Our ref: HA/2019/121136/01-L01
Your ref: FG/171/18/DOC
Date: 06 March 2019

Approval of details reserved by condition imposed under FG/39/18/PL relating to conditions 3-surface water drainage, 4-ground contamination risk, 9- position & intensity of lighting filaments, 14-lighting scheme, 15-construction management plan & 16-ground contamination risk

Worthing Peugeot, Littlehampton Road, Ferring, BN12 6PB

FIGURE 2: INVESTIGATION LOCATION PLAN

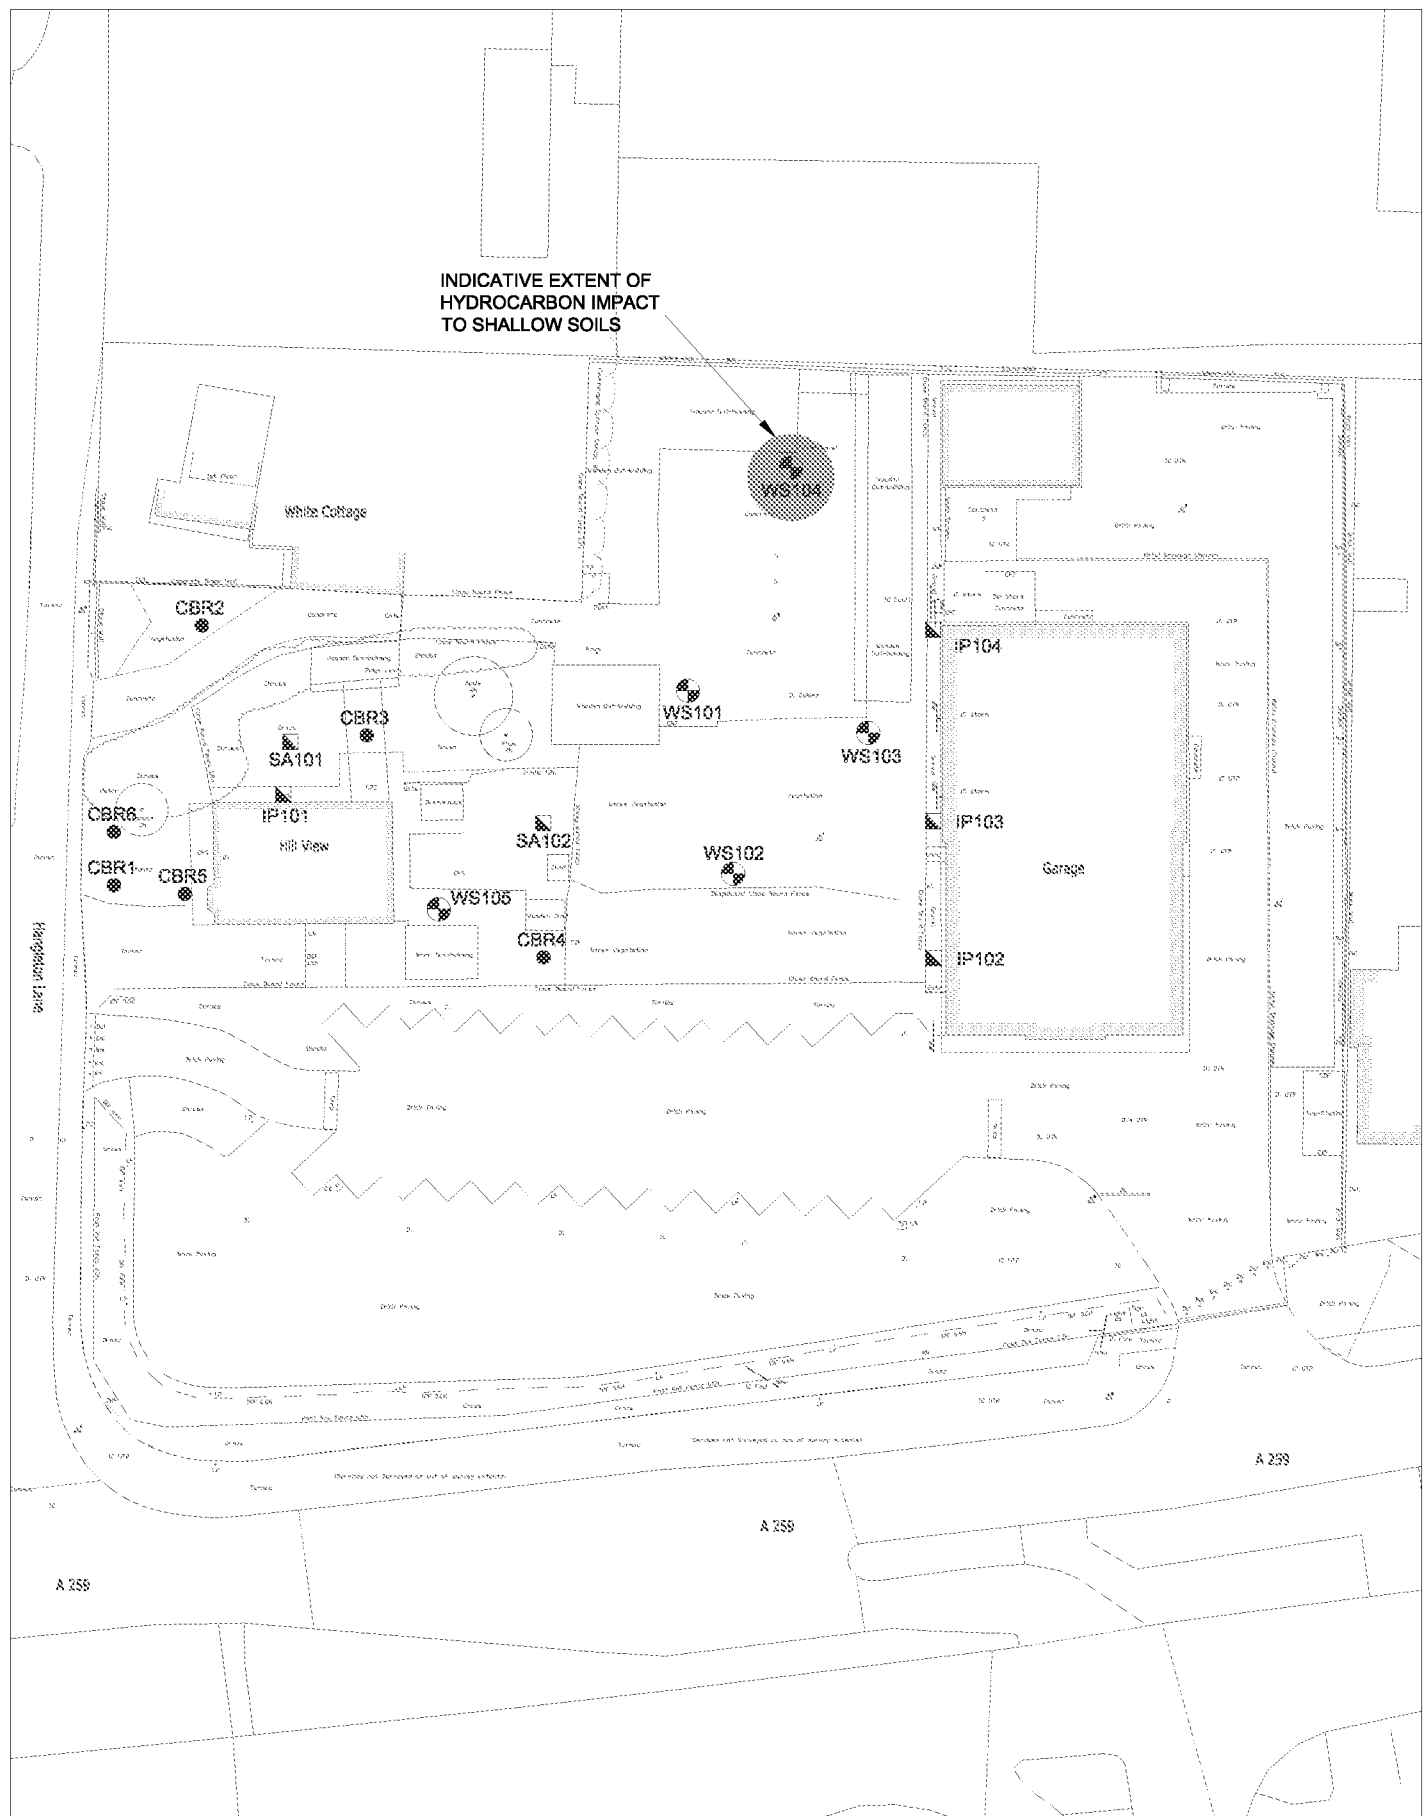
We have reviewed the Ground Condition assessment (J18-035-R02). This identifies localised hydrocarbon contamination in the vicinity of WS104 and hydrocarbon odour in WS103. Section 5.2.3 states that groundwater locally has been slightly impacted with hydrocarbon contamination already and that as concentrations in the soil are low this does not represent an ongoing source. However no samples have been taken between WS104 and WS103 and groundwater samples have not been reported.

Therefore we are **unable to recommend the discharge of conditions 4 and 16** and would like to see further investigation to determine the extent of the impact in soils and groundwater around WS104 and the hydrocarbon odours observed in WS103. This should be incorporated into the conceptual model and then a remediation strategy and subsequently a verification strategy submitted (if required).
